Historic England Answers to ExA's first Q's

Figure App.13.5-22:  
ZTV from Fillingham Castle (NHLE 1166045)

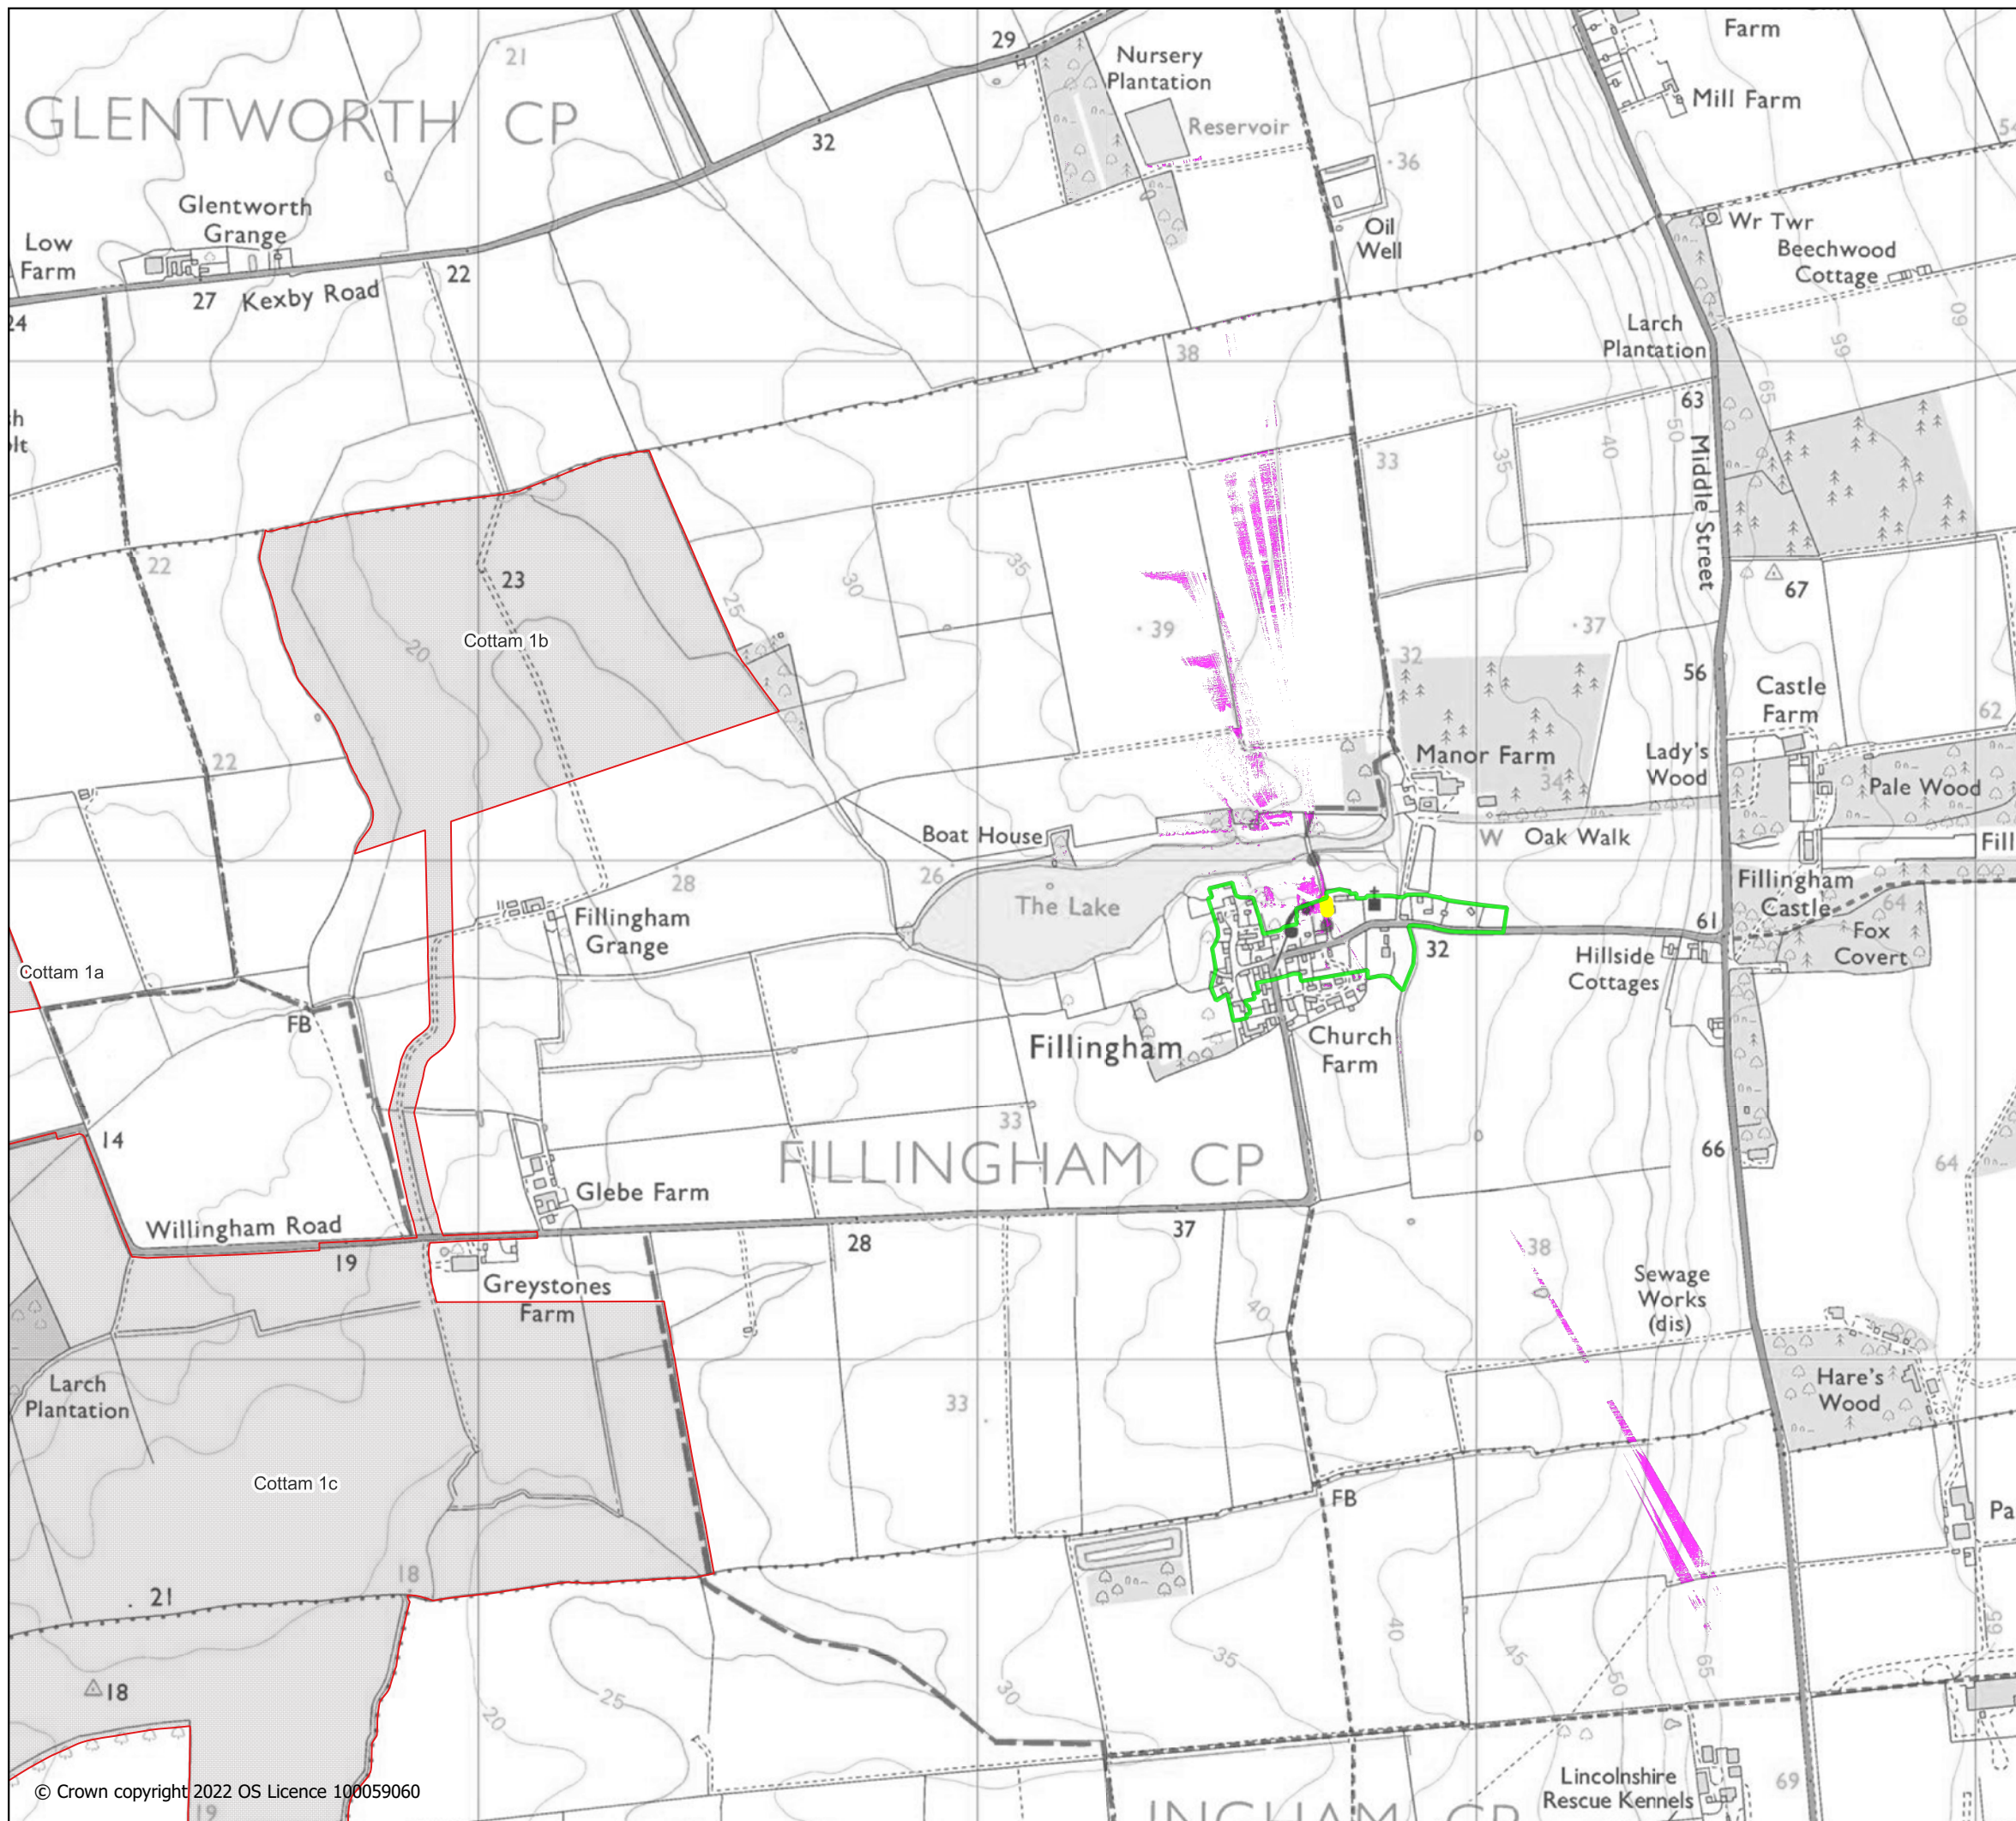
The lowered level of adverse effect upon the significance of the Grade I listed Fillingham Castle selects from an initial assessed impact of Slight or Moderate. We note the argument set out at the above references as to likely visibility and prominence of panels at distance in this landscape context. Selection between Slight and Moderate impact introduces what may be the illusion of precision given the variety and multiplicity of individual visual experience of the Grade I house in its designed and borrowed landscape setting which need to be encompassed into that singular assessment. We also note that views from upper rooms and battlements / lead flats on the Castle itself were not accessible to assessment and are likely to be very broad. It may be safest to regard the likely level of impact as not worse than Moderate, with the potential to be Slight depending upon the actual visual experience of the scheme in the landscape.
